Our Ref: P/113/19/HH
Your Ref:

Town & Country Planning Act 1990 (as amended)
Town & Country Planning (Development Management Procedure) (England) Order 2015
Application for Planning Permission for Works or Extension to a Dwelling

Development Single storey rear extension
Location 4 Lion Road Pagham

Block Plan

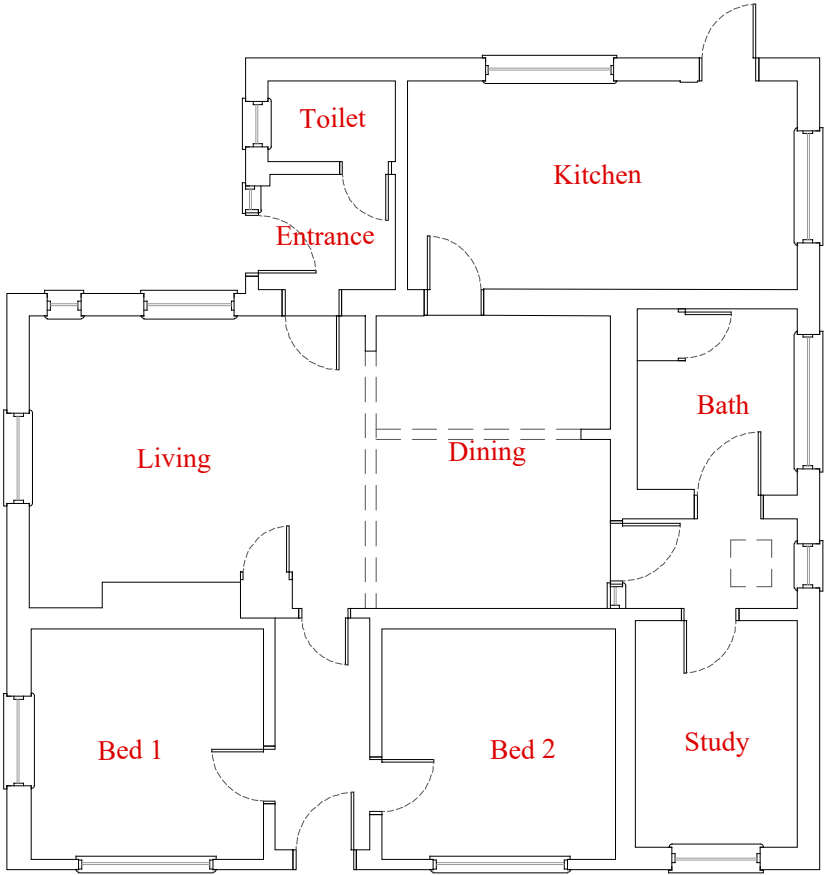
Block Plan: You are required to have dimensions from the proposed extensions to all site boundaries on the block plan. Please amend.
